Your Ref: EN010151
Our Ref: 23/0471/NSIP
Contact: [REDACTED]
Email: [REDACTED]@n-kesteven.gov.uk

12 January 2026

RE: Beacon Fen Energy Park DCO – Deadline 6 Submissions for North Kesteven District Council

Soil Stockpile Design

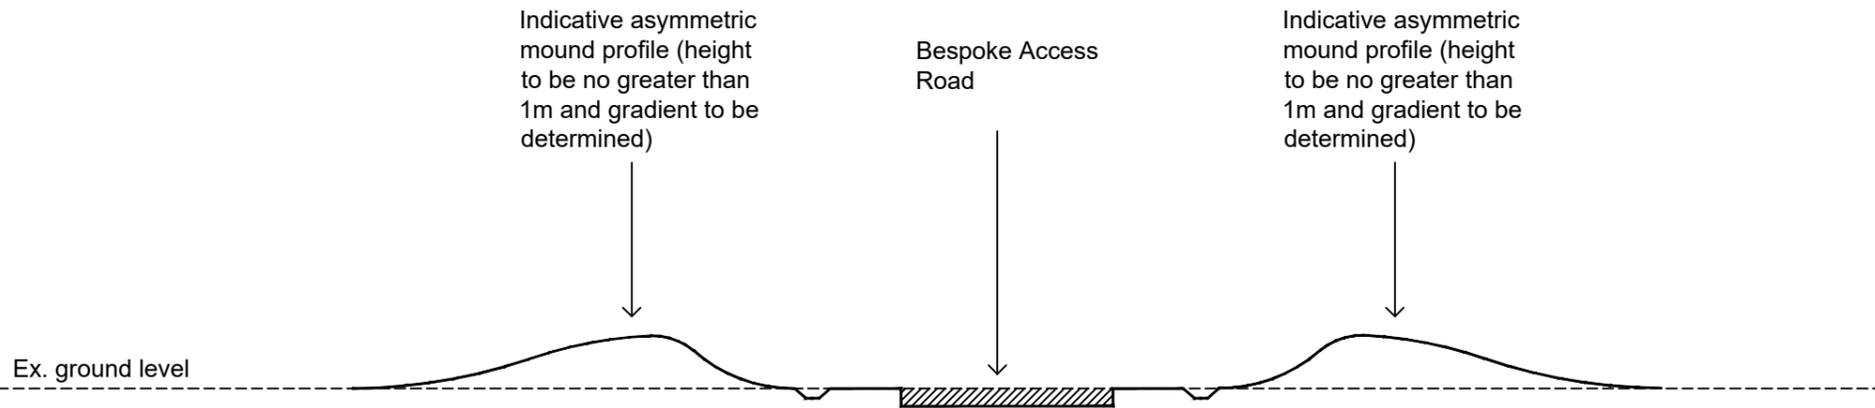
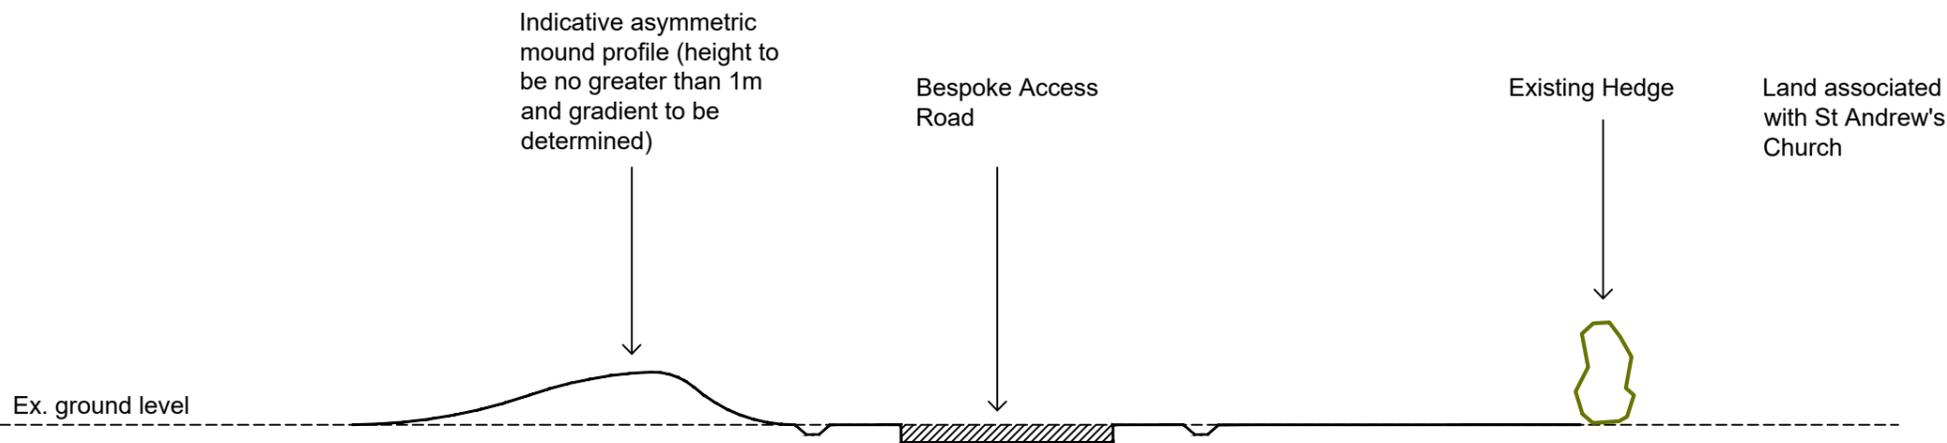
Whilst the soil stockpile would, to some extent, screen the road, the Council is concerned that it will in its own right appear as an alien feature within the landscape. It also doesn't give opportunity for "growth" to enable the road screening to further mature. With the existence of mature hedgerows within close proximity the Council would prefer a semi-mature hedgerow planted as a screening feature, which would be more sympathetic to the immediate context of the site. The Council disputes the fact that the stockpile would result in the character of a ha-ha. Whilst these are common features in association with designed landscapes, this feature will not have the characteristics of a ha-ha, and will not have the same effect (of a continuous flat landscape).

Paragraph 6.3.20 of the updated LVIA identifies stockpiles at 0.5m to 1.0m in height adjacent to the bespoke access road. There are two concerns in regard to these features:

1. The bunding would be out of character in this landscape and would likely appear as an engineered feature. This is a relatively flat, open landscape, and bunding such as that proposed would potentially be conspicuous in views and out of character with the existing landscape. We do however acknowledge that these are currently proposed as relatively low features, lessening their presence in views. Paragraph 6.6.57 of the LVIA has been updated to consider these new features, however we disagree that these elements will harmonise with the immediate context of the agricultural landscape as they will likely appear as engineered elements out of character with the existing landscape character and in themselves have the potential to have adverse landscape and visual effects; and

2. A topsoil stockpile for use decades later is not likely to be effective. We would welcome clarification from the applicant in this regard and a maintenance process that would maintain the topsoil integrity, but topsoil stockpiles are typically in place for a relatively short amount of time, usually 6 to 36 months. The characteristics of the soil are likely to change over a protracted period of time when in a stockpile, and in our experience unlikely to be useable.
